### **East Anglia One North (EA1N) and East Anglia Two (EA2) Offshore Wind Farms**

**Planning Inspectorate Reference: EA1N – EN010077 & EA2 – EN010078**

**Deadline 5 - 3 February 2021**

**East Suffolk Council's Summary of Oral Case - Issue Specific Hearing 6**

200

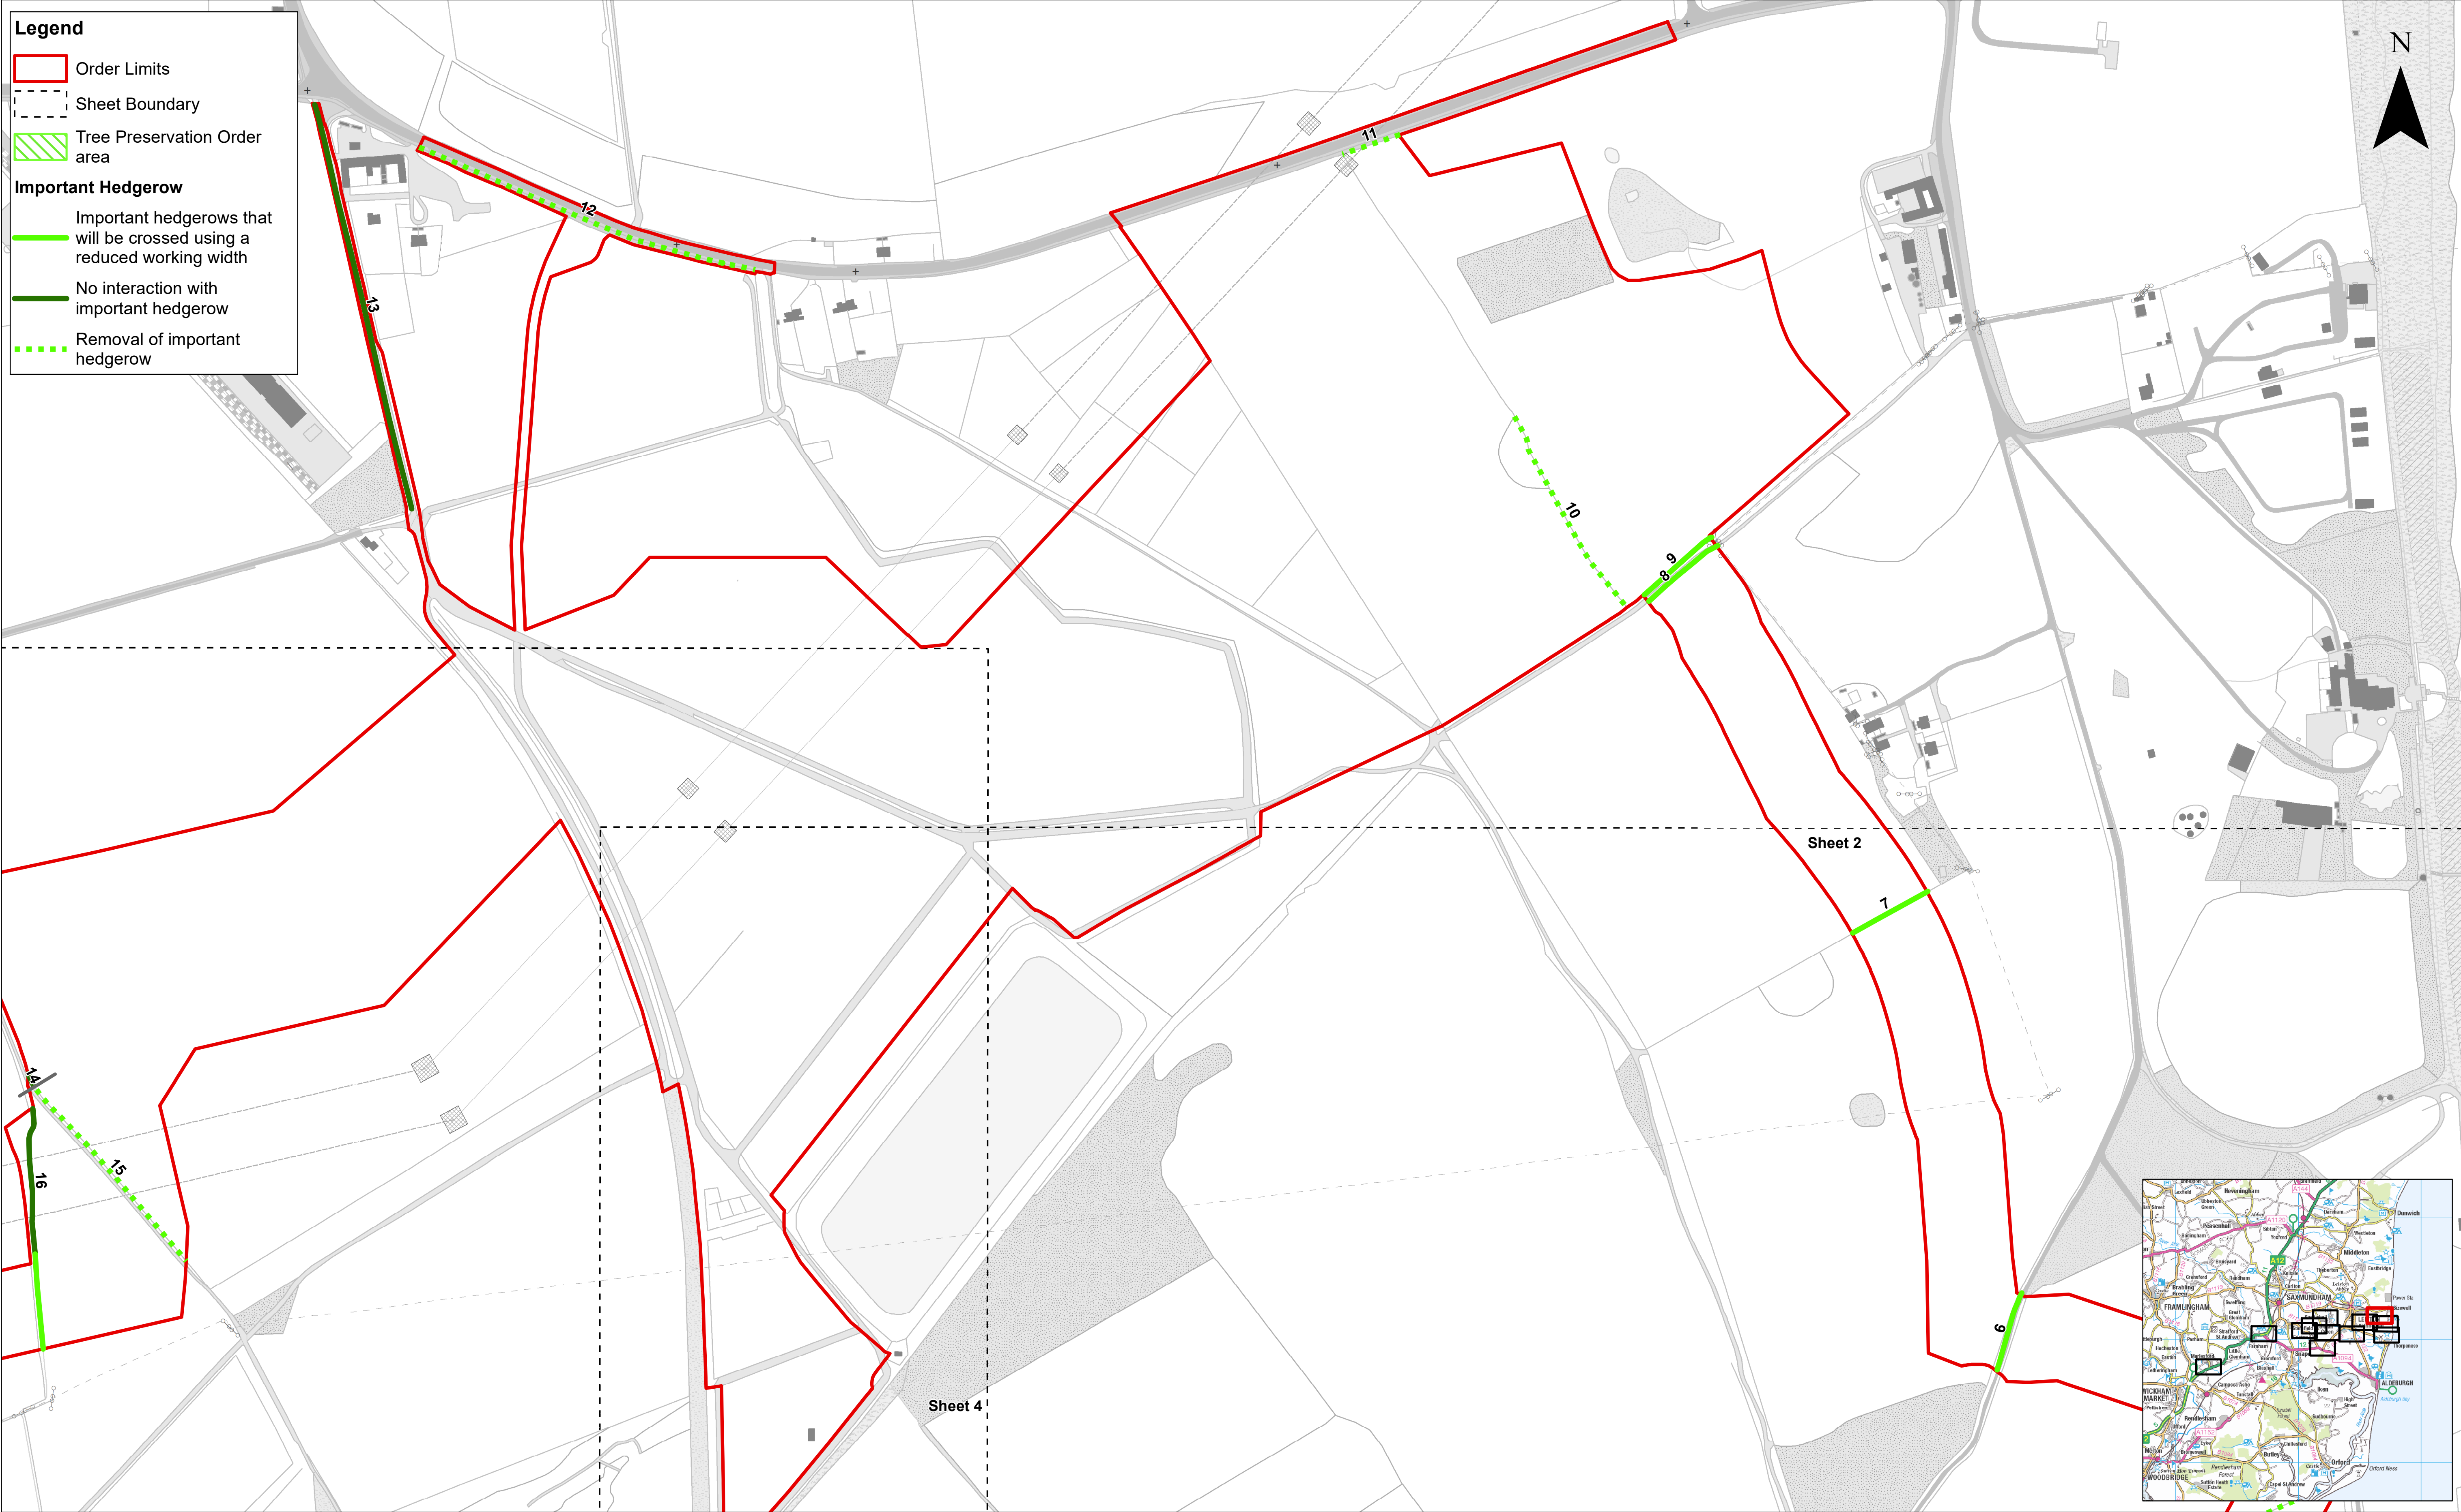
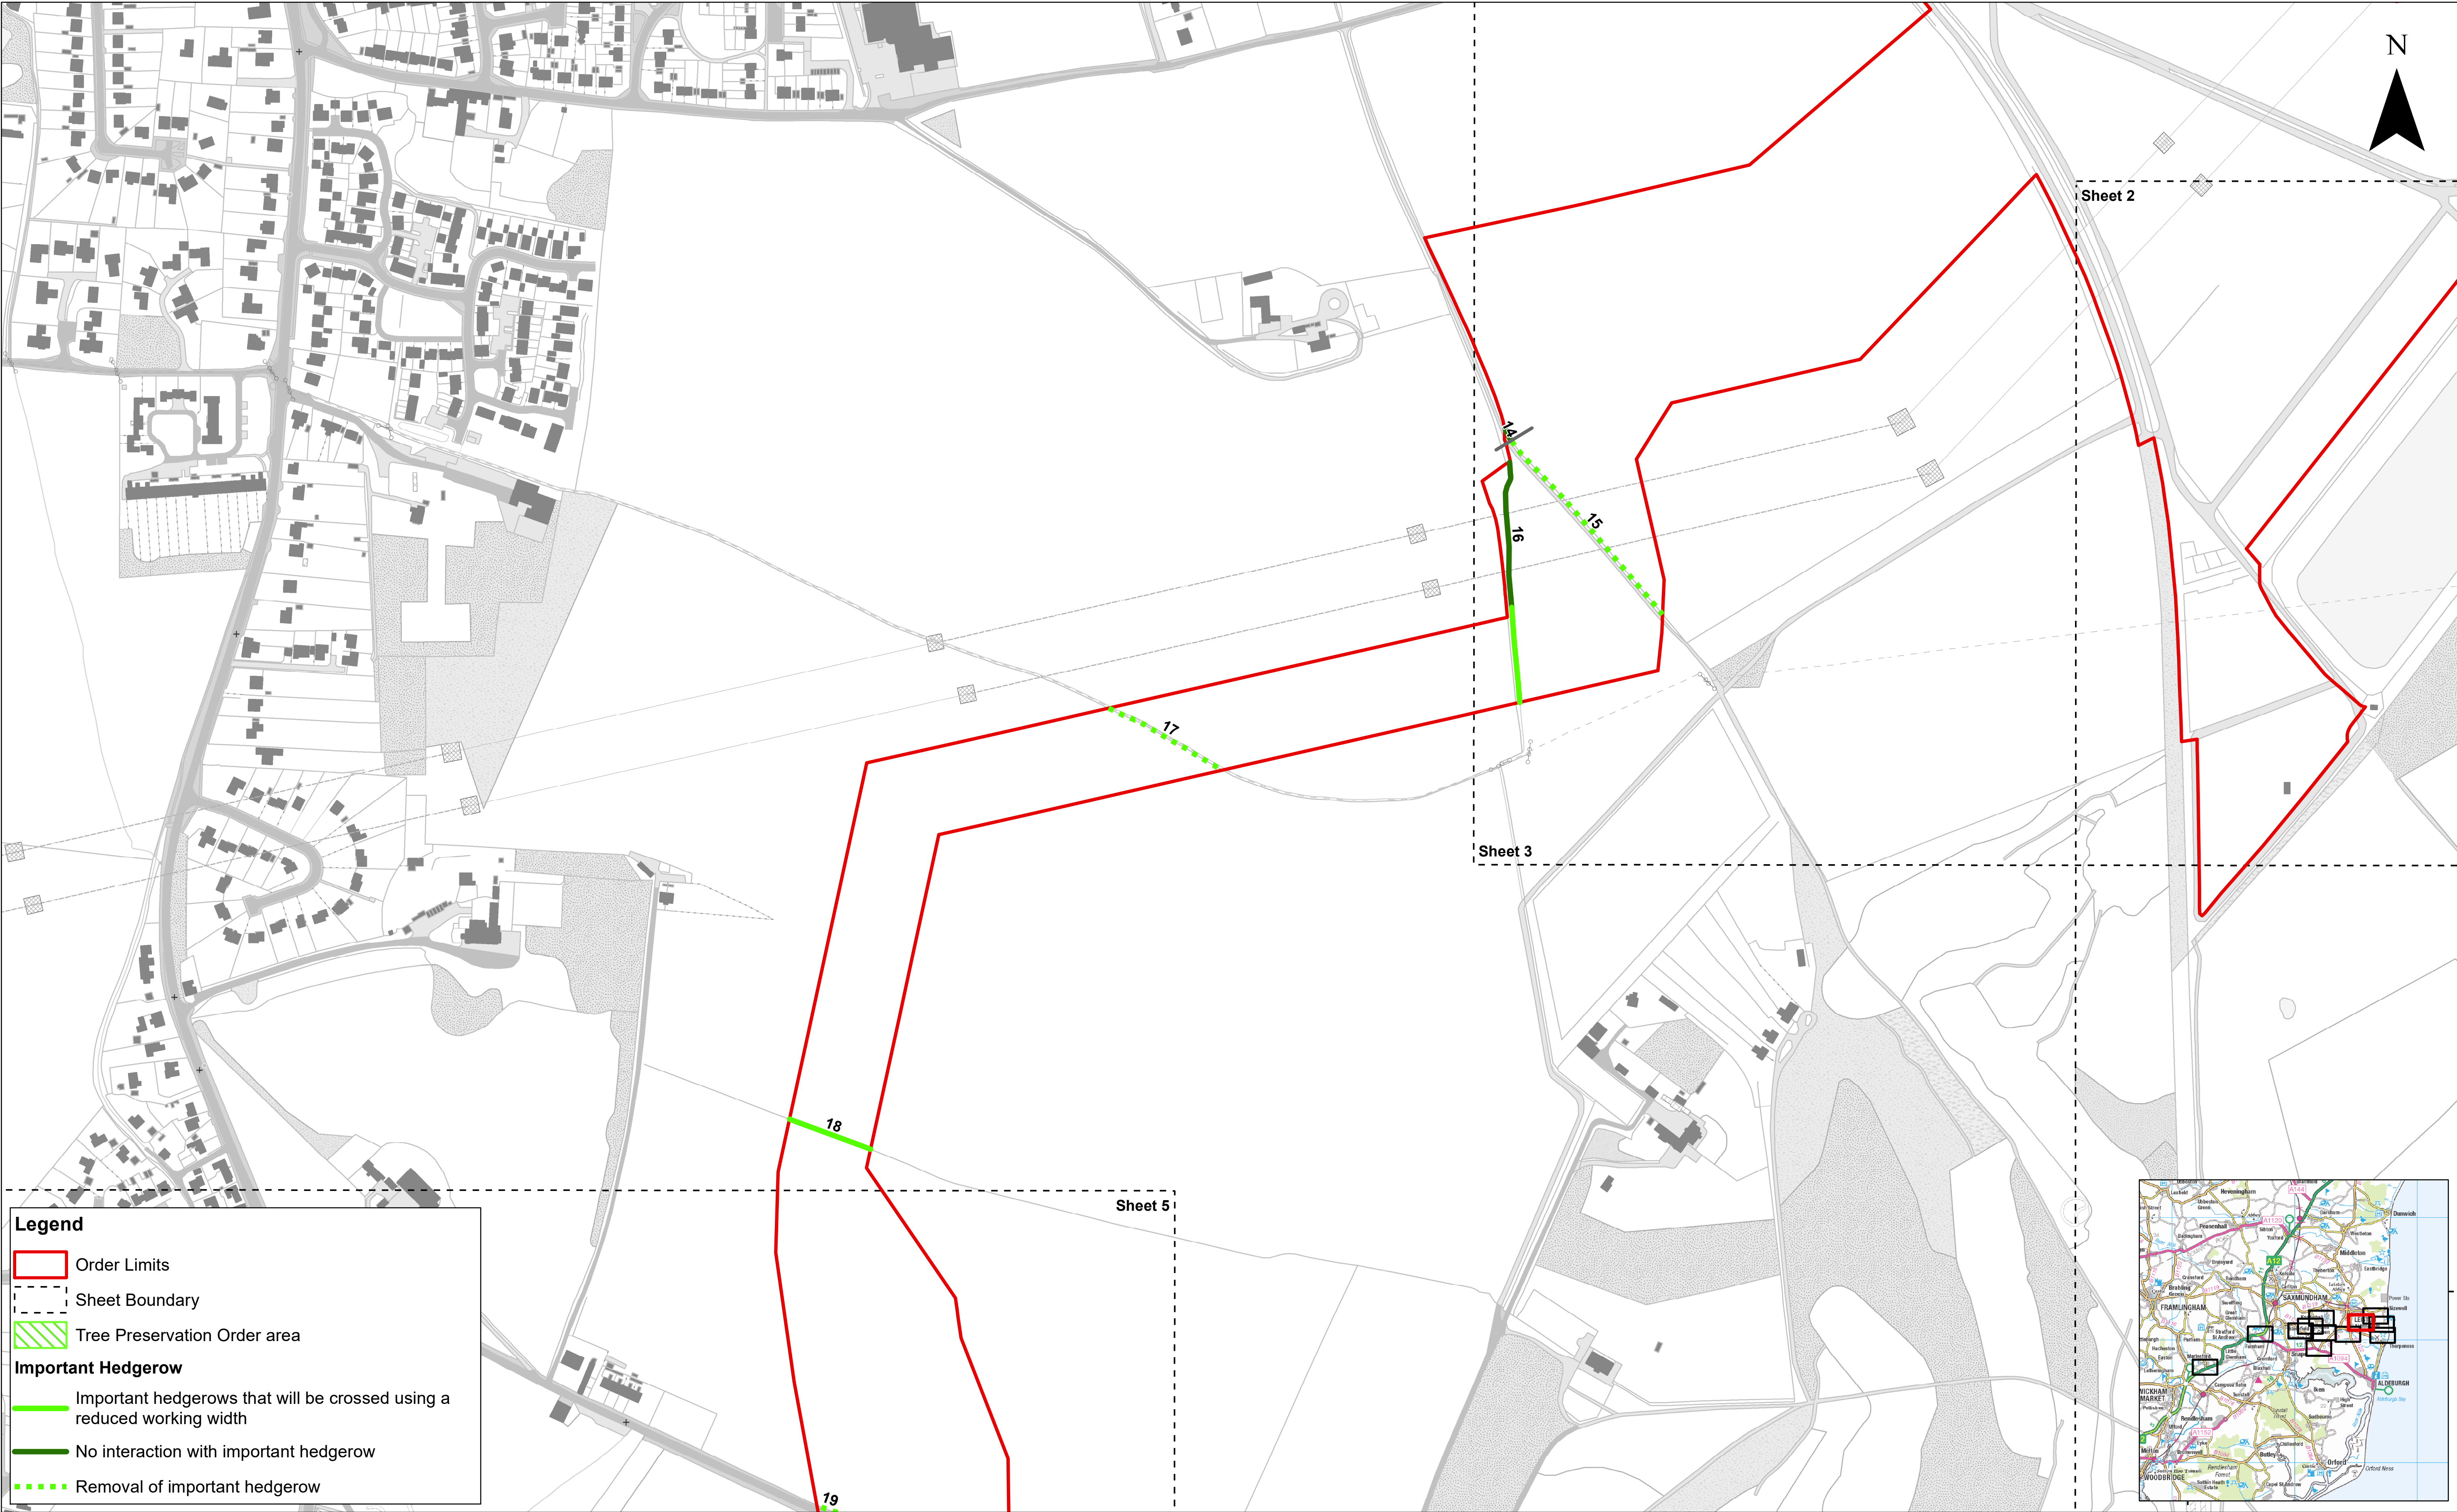
ESC supports SCC and the Applicants submissions in relation to the MoU. It is considered that a requirement is not necessary and could restrict the flexibility and dynamism which the MoU in its current form allows.
Schedule 11 – Hedgerows Part 1 – Removal of Important Hedgerows		<p>ESC seeks clarity regarding the hedgerows identified with Schedule 11 of the draft DCOs.</p> <p>ESC seeks clarity regarding the hedgerows identified within Schedule 11 of the draft DCOs.</p> <p>Hedgerows marked 1 and 2 are identified within Schedule 11 (REP3-011) as being removed but on the Important Hedgerows and Tree Preservation Order Plan (REP3-010) they are identified as being crossed with a reduced width. Annex 1 of the OLEMS document (REP3-030) identifies hedgerows 1 and 2 as being subject to full or partial removal. Clarification on this is required.</p> <p>Clarification is also required in relation to hedgerow marked 28 which is identified on the Important Hedgerows and Tree Preservation Order Plan (REP3-010) as being removed but is not identified within Schedule 11 as being removed and identified in Annex 1 of the OLEMS (REP3-030) as not subject to interaction.</p> <p>The interaction identified within Annex 1 of the OLEMS (REP3-030) in relation to a number of hedgerows does not appear to correspond to the interaction identified within Schedule 11 of the draft DCOs (REP3-011) and the interaction identified on the Important Hedgerows and Tree Preservation Order Plan (REP3-010). Further clarification as to the reasons for this is required. Does Annex 1 identify a greater</p>

number of important hedgerows to be crossed with a reduced width as some of these will be crossed with a width less than 32m but greater than the draft DCOs definition of reduced width which is 16.1m?
<p>Schedule 16 – Procedure for discharge of requirements</p> <p>1 – Applications made for certain approvals</p> <p>2 – Further information</p>		<p>ESC understands that this procedure is set out in Appendix 1 of The Planning Inspectorate's 15: Drafting Development Consent Orders but there have been a number of recent DCOs which have been granted with wording which varies from that set out. ESC is particularly referring to the two latest decisions on offshore windfarms published relating to Hornsea Project Three and Norfolk Vanguard Offshore Wind Farms.</p> <p>Schedule 16 does not include any details in relation to the information the Applicant should provide. For example, the Norfolk Vanguard DCO included the wording:</p> <p><i>"a) the undertaker must give the discharging authority sufficient information to identify the requirement(s) to which the application relates;</i></p> <p><i>"b) the undertaker must provide such particulars, and the request be accompanied by such plans and drawings, as are reasonably considered necessary to deal with the application."</i></p> <p>The Council considers that this would be useful additional wording.</p> <p>1(2)(a) ESC considers that 42 days provides an insufficient standard time period in which to discharge requirements. It is noted that this is the timescale set out in Appendix 1, however a longer period of 56 days is provided when discharging planning application conditions and therefore a shorter period is not considered appropriate. The DCOs and requirements relate to multiple large scale complex developments which will require significant resource from ESC and consultation with</p>
